# OAKLANDS FARM SOLAR PARK

The Applicant's Comments on Written Representations and Other  
Deadline 5 Submissions

November 2024

Document Ref: EN010122/D6/14.2

Drawing Title
**Works Plan
 Sheet 2**

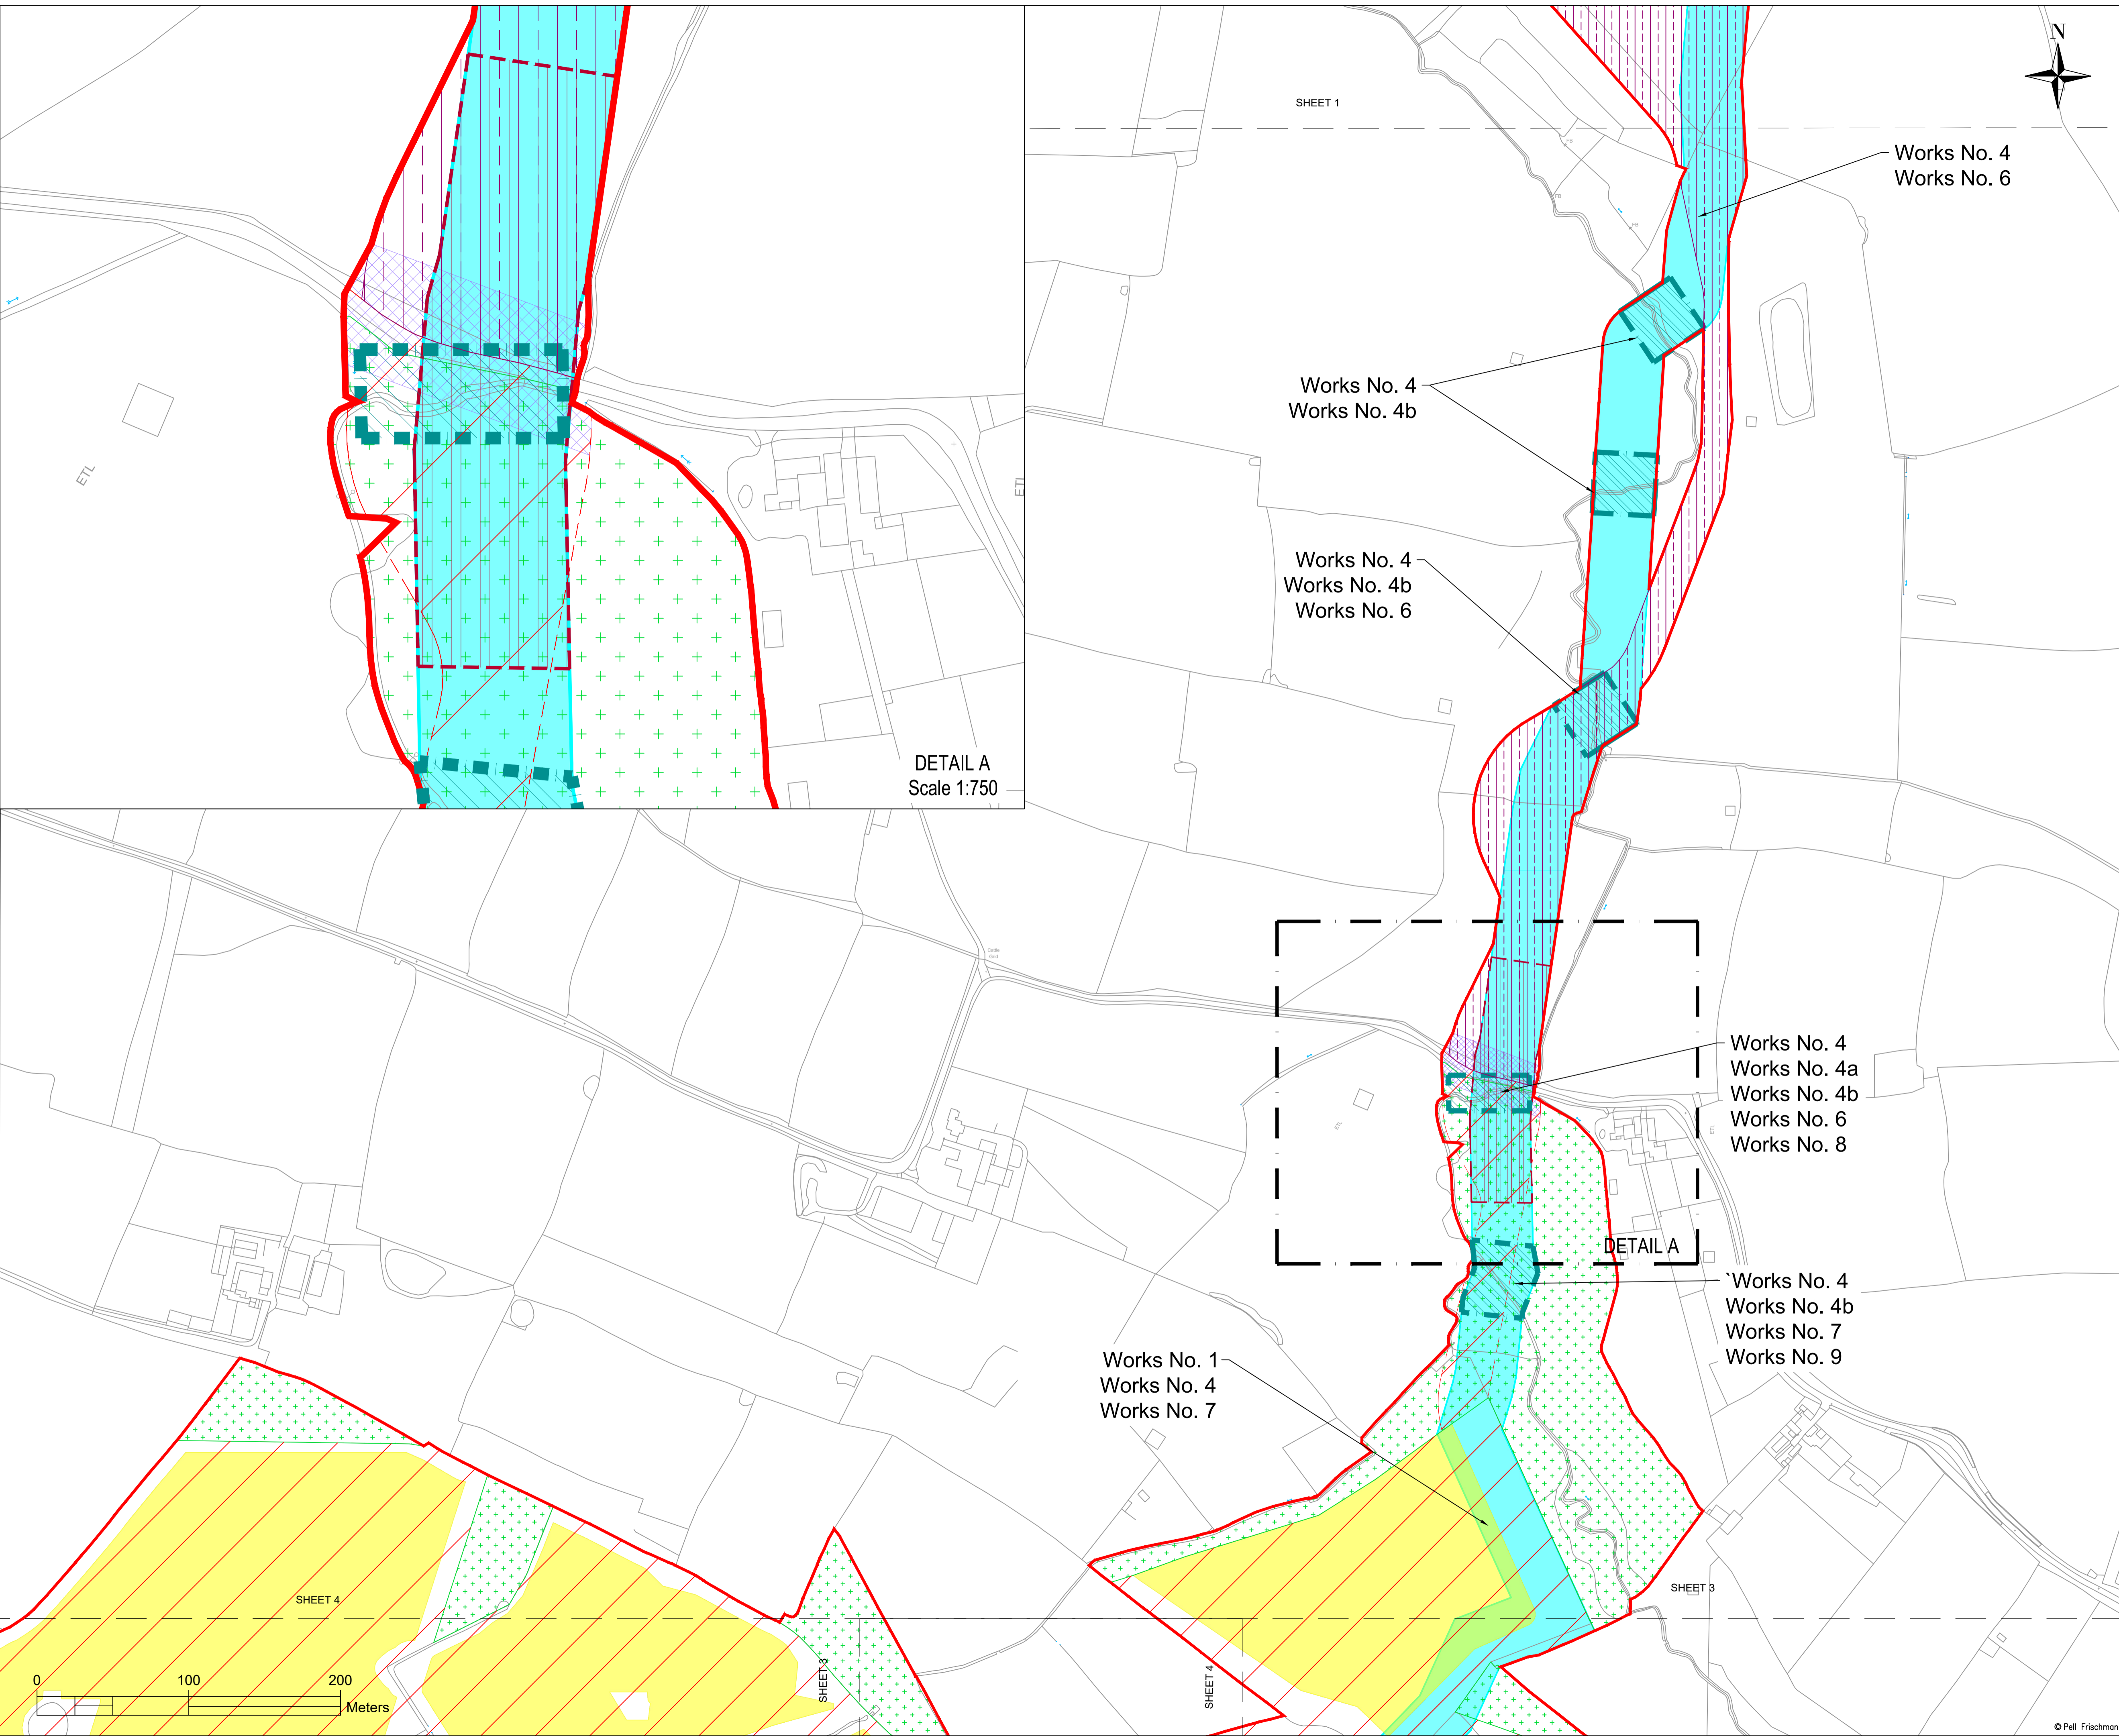
ITEM:	ACTION	SDDC ANSWER:	APPLICANT'S RESPONSE AT D6
<b>Other matters SDDC noted as Action Points not listed by the ExA</b>			
a)	<p>Clarification on areas of concern around the Haul Road.</p>	<p>The submitted Works Plan from Pell Frischman reference Sheet 2, Drawing number SK02 (Examination Library ref APP-007) shows the route of proposed haul road. The HSE recommends that haul roads should be three and a half times the width of the widest vehicle using them, in this case HGVs.</p> <p>The 'Site Works Plan' Sheet 2, ref: SK02 shows that areas between worksareas 4 and 6 will be directly affected by the proposed haul road, that will cut a swath through the valley bottom, dissecting and disconnecting areas of dense and mature vegetation and habitat, cutting across the watercourse, in locations where there are known to be otters, barn owls and bats. Further, works 4 and 4b will cut across the water course three times, through dense and mature habitat, with attendant clearance and disturbance that will radically alter the tranquil and bucolic appearance of the landscape in this location.</p>	<p>The Applicant has provided a detailed response covering this matter in its response to ExQ3 7.9 in document 14.3 submitted at Deadline 6.</p>
